Consultation Response from: KC Environmental Health (Pollution & Noise Control)
2024/92109 Mark Betts Hair and Beauty, 43 Commercial Street, Batley, WF17 5EP
Change of use of ground floor from salon (Class E) to restaurant (Class E(b)), installation of rear external extraction flue and formation of bin storage area to rear
**Responding Date:
7th October 2024**
**Responding Officer:
SR**
**Responding Ref:
WK202430852**
Comments

REF: PE-02

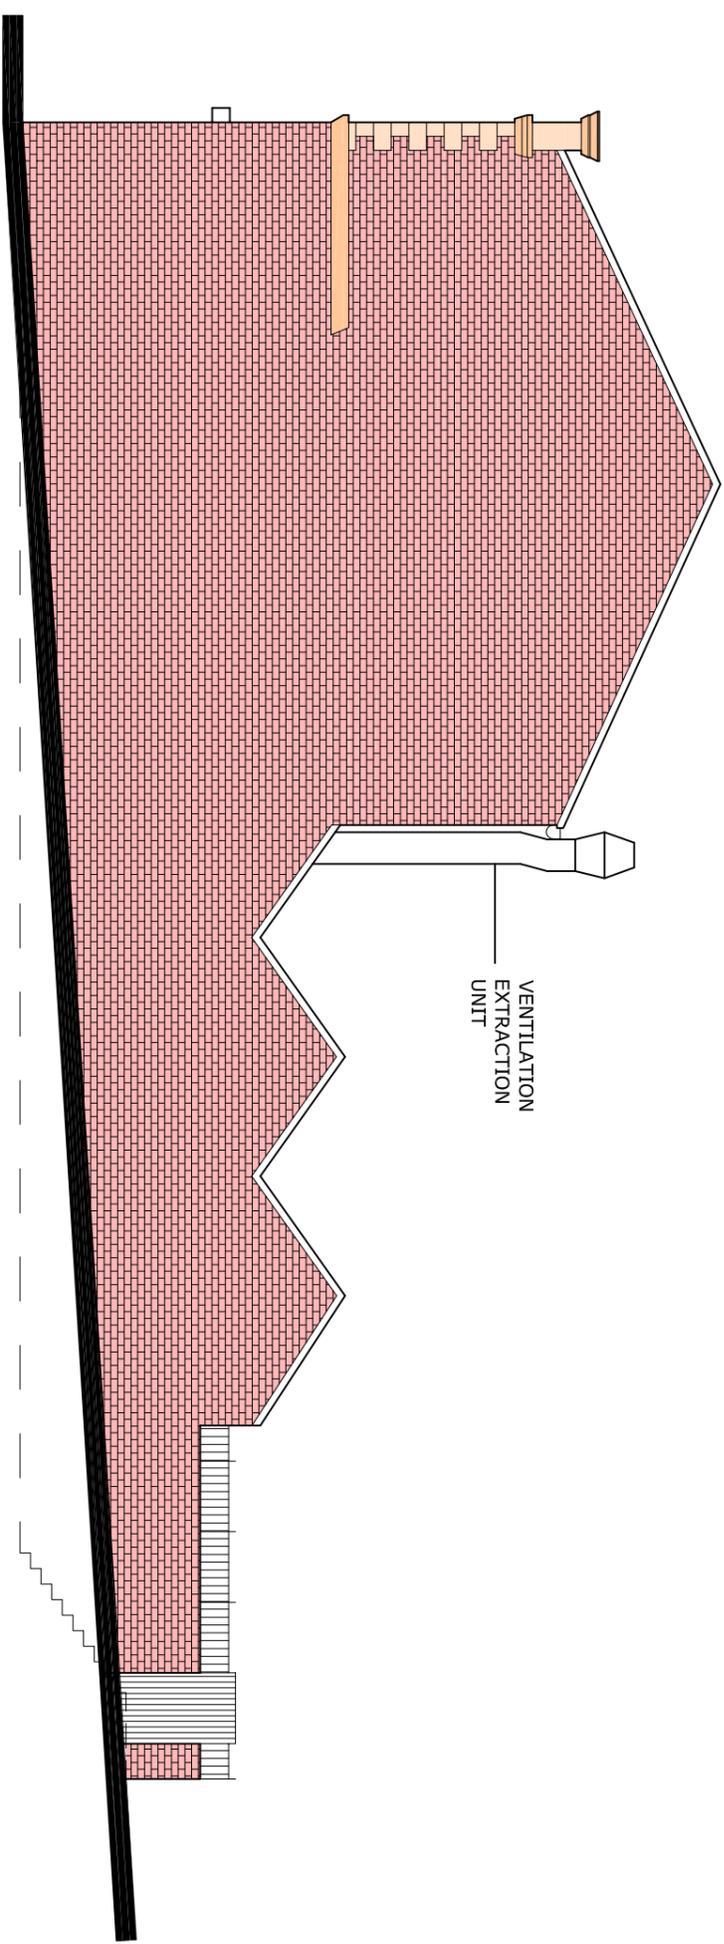
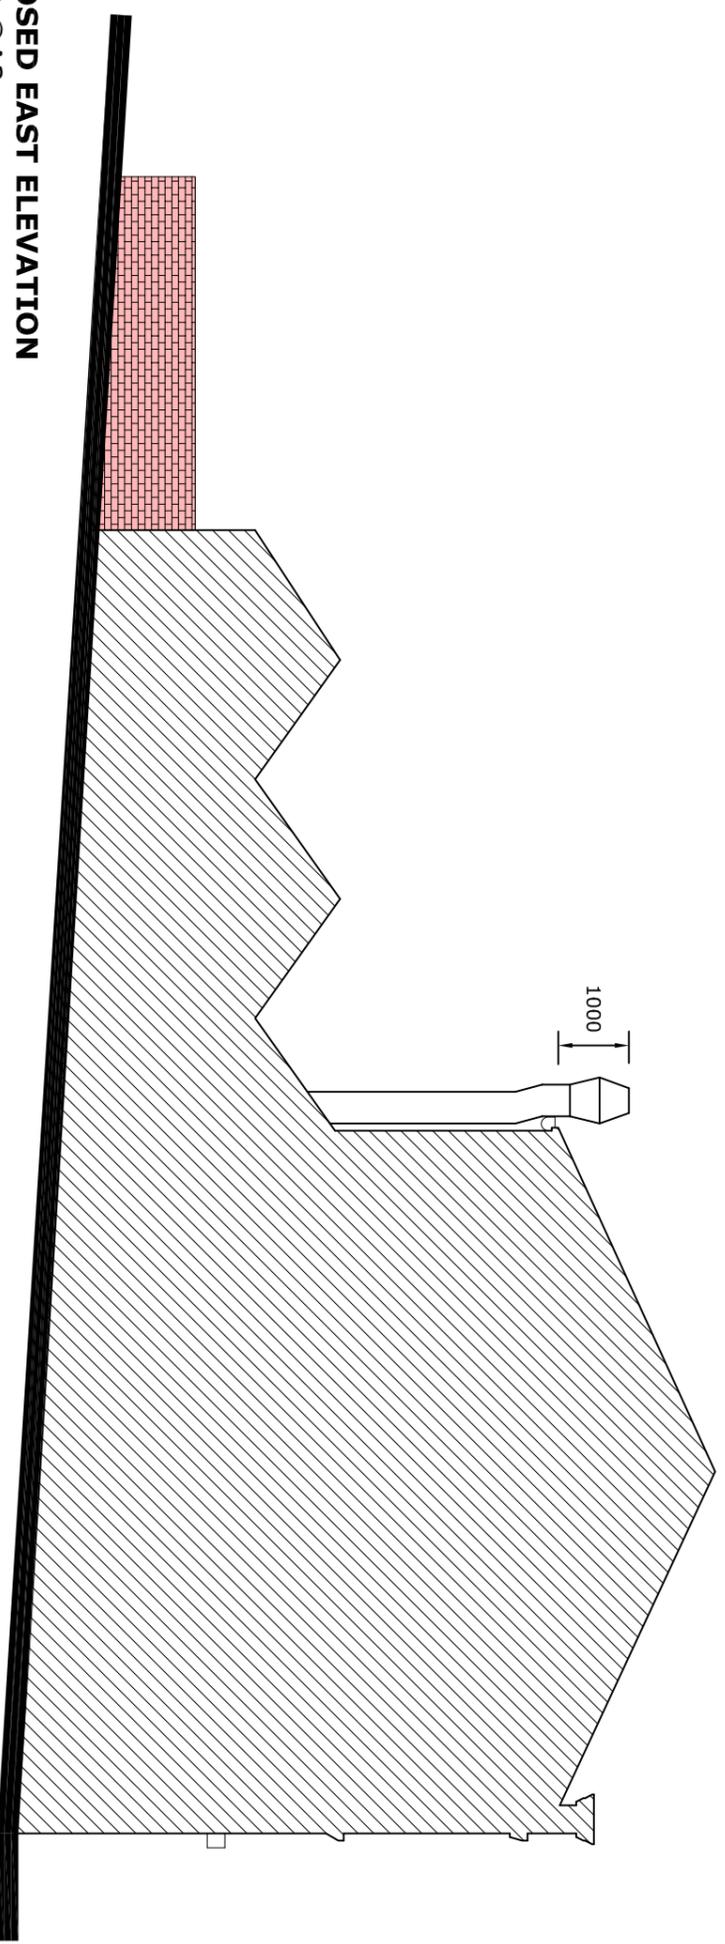
In regard to odour an assessment using Guidance on the Control of Odour and Noise from Commercial Kitchen Exhaust Systems, was undertaken, due to the type of food proposed a high level of odour control is required. Section 6.02 of the report details a high level odour control requires: a) a canopy to cater for medium loading (0.35 m/s), and b) pre-filters and carbon filters to achieve a 0.2 to 0.4 second residence time. This is in line with the proposed odour control system (see Appendix 7). Appendix 7 shows a get cowl fitted to the terminus and the plan accompanying the application shows terminus height 1m above the eaves.

Before any food cooking commences the kitchen extract system as specified in RP Acoustics Limited, ref: Our Reference: NIA&ORA/1300/24/365/v1.0/43 Commercial Street, Batley, dated the 2nd of September 2024 and the plan by 363 Architecture, ref: PE-02, dated July 2024, shall be installed. The kitchen extract system shall operate at all times during the preparation and cooking of food and be maintained in accordance with the manufacturer's instructions and as specified in the report.
